From: Michael Brewster <michael_brewster@hotmail.com>
Sent: Wednesday, 25 March 2015 8:53 AM
To: Simon Truong
Cc: cmoore@cityofsydney.nsw.gov.au; office@goward.minister.nsw.gov.au; Heffron@parliament.nsw.gov.au; Omar.Rodriguez@parliament.nsw.gov.au; Amy Watson
Subject: RE: 60-78 Regent Street Redfern Development Application

Re: State Significant Development 6724 – 60-78 Regent Street, Redfern

SSD6724 – Mixed Use Student Accommodation Development at 60-78 Regent Street, Redfern

Figure 2 – Proposed detail of angled window hoods

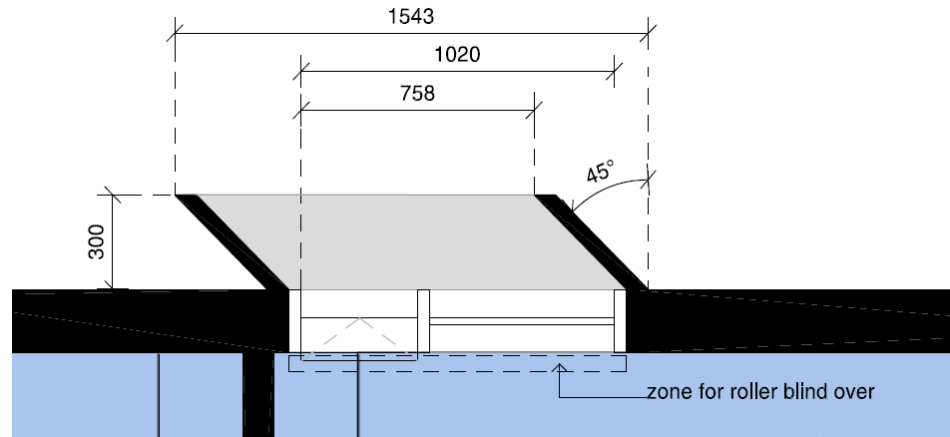
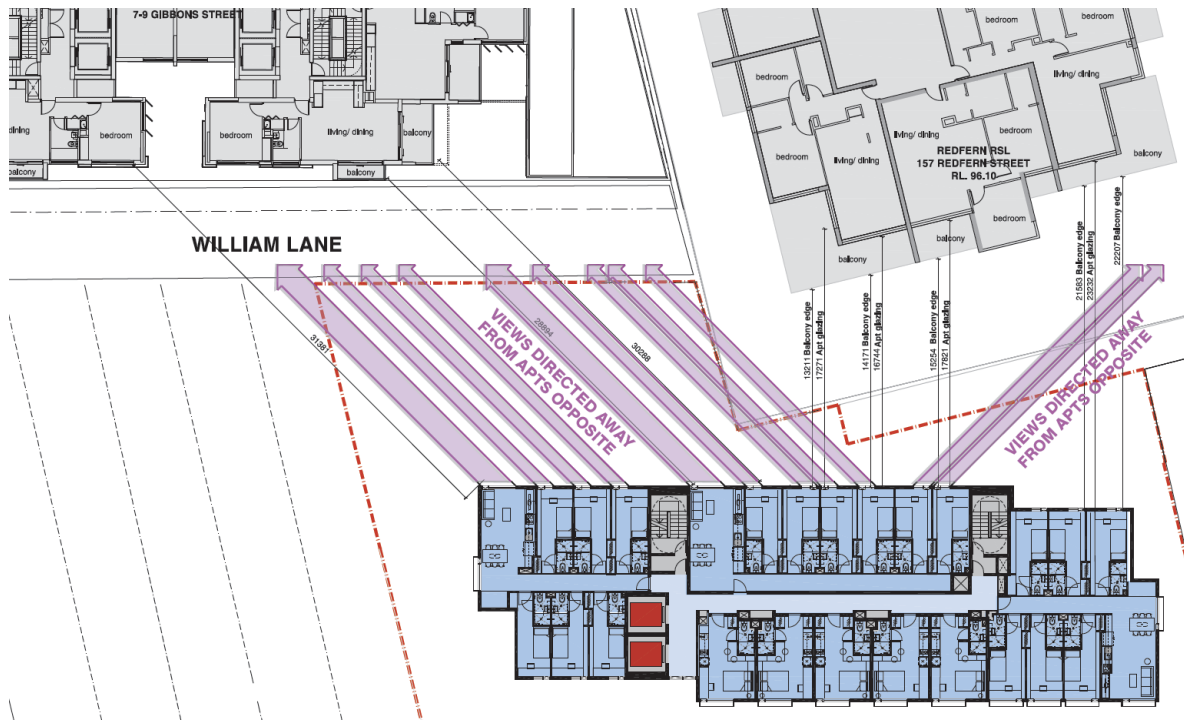
- **2.1 Privacy** – I submit that the efforts by proponents to direct views from proposed bedrooms with angled window hoods are not satisfactory. (Refer to **Figure 2**) Though attempts are made to direct views away from apartments opposite, there are still opportunities for overlooking. Further, views from windows are directed towards the neighbouring tower in 7-9 Gibbon St which may result in further privacy concerns for existing buildings and residents in close proximity. Given the fact students spend a lot of time in their room and study desk, privacy concerns on overlooking is severe and present a direct visual interference to current resident on the east-facing side of 157 Redfern St. I submit that inadequate steps are taken to address the privacy concerns in the proponent's response to submissions.

**Figure 7** – View impacts to dwellings within Redfern RSL building
Source: Bates Smart

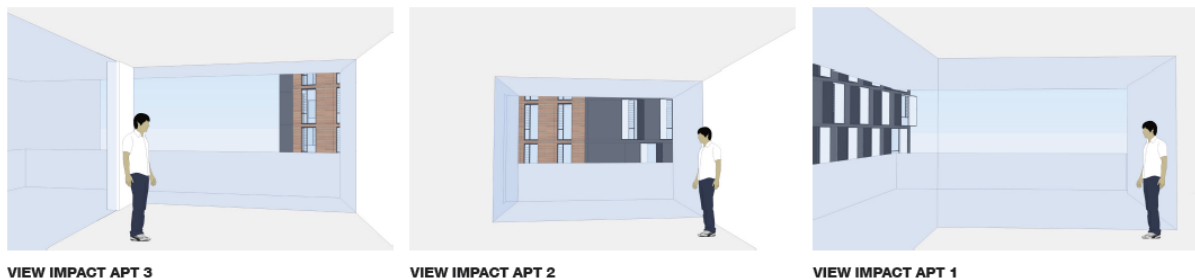
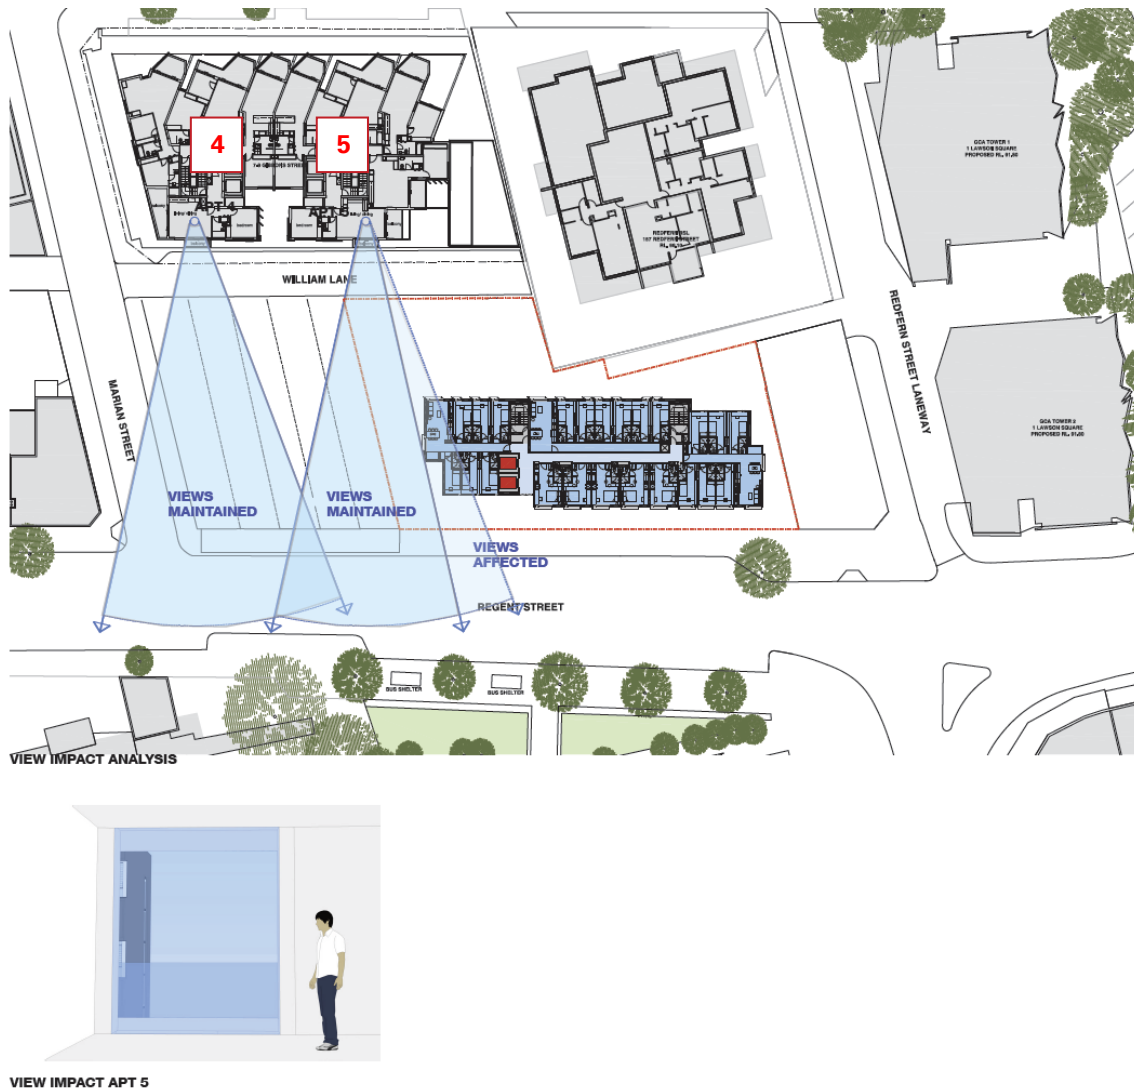
- **1.1 View Loss** - I submit that it is unacceptable for the proposed development to result in extensive loss of views from a number of adjoining dwellings, and the complete loss of views to a number of single-aspect apartments. (**Refer to Figure 1**) According to RFDC, the planning controls and laws establish objectives to minimise the impact of proposed development on light, air, sun, privacy, views and outlook for neighbouring properties, including future buildings. The proposed development should not adversely impact, at the expense of existing residents and community. The Proponent's submission that there is no reasonable expectation for dwellings at 157 Redfern St and 7-9 Gibbons St to enjoy eastern views is unfounded. The fact that existing buildings were developed earlier, in compliance with the planning controls and laws, gives the existing residents access to amenities such as solar access, visual and acoustic privacy, lack of overshadowing and visual and view impacts. Future or proposed development should only be approved after thoroughly assessing the impacts to residential amenities on existing developments. Given the large number of objections from the public on impacts of the proposed development, I propose NSW Planning & Environment to closely consider impacts raised by the public.

Figure 13 – Building separation measurements
Source: Bates Smart

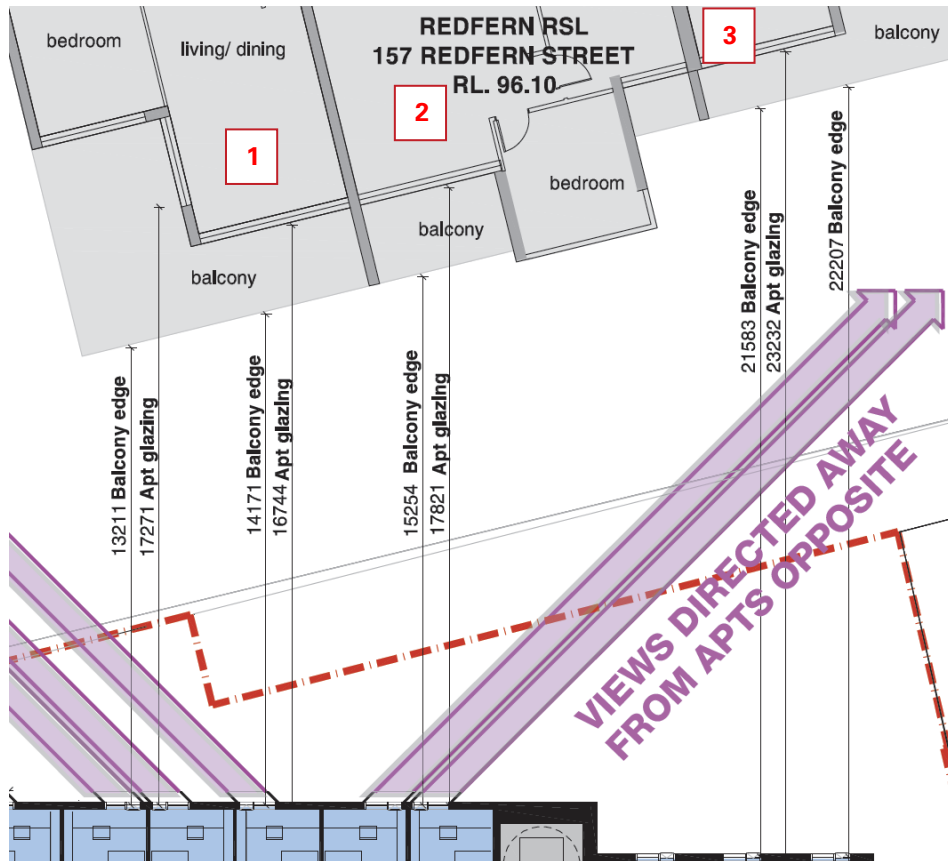
- **3.1 Building Separation** - I submit that the proponent did not address the minimum building separation of 24m proposed by the City of Sydney Council to provide visual and acoustic privacy for existing and new residents as set out in SEPP 65 and RFDC planning controls. The proposed development remains at 13m separation from the adjoining 157 Redfern St development where habitable living areas are directly facing each other. I submit there is no adequate coordination of building separation controls with controls for daylight access, visual privacy and acoustic privacy. I submit the intra-block separation provided between existing buildings at 7-9 Gibbons Street/ 157 Redfern Street and 1 Lawson Square is distinguished from the proposed development as the habitable aspects of the existing buildings are not directly facing each other as in the case of the proposed development on the existing apartments.
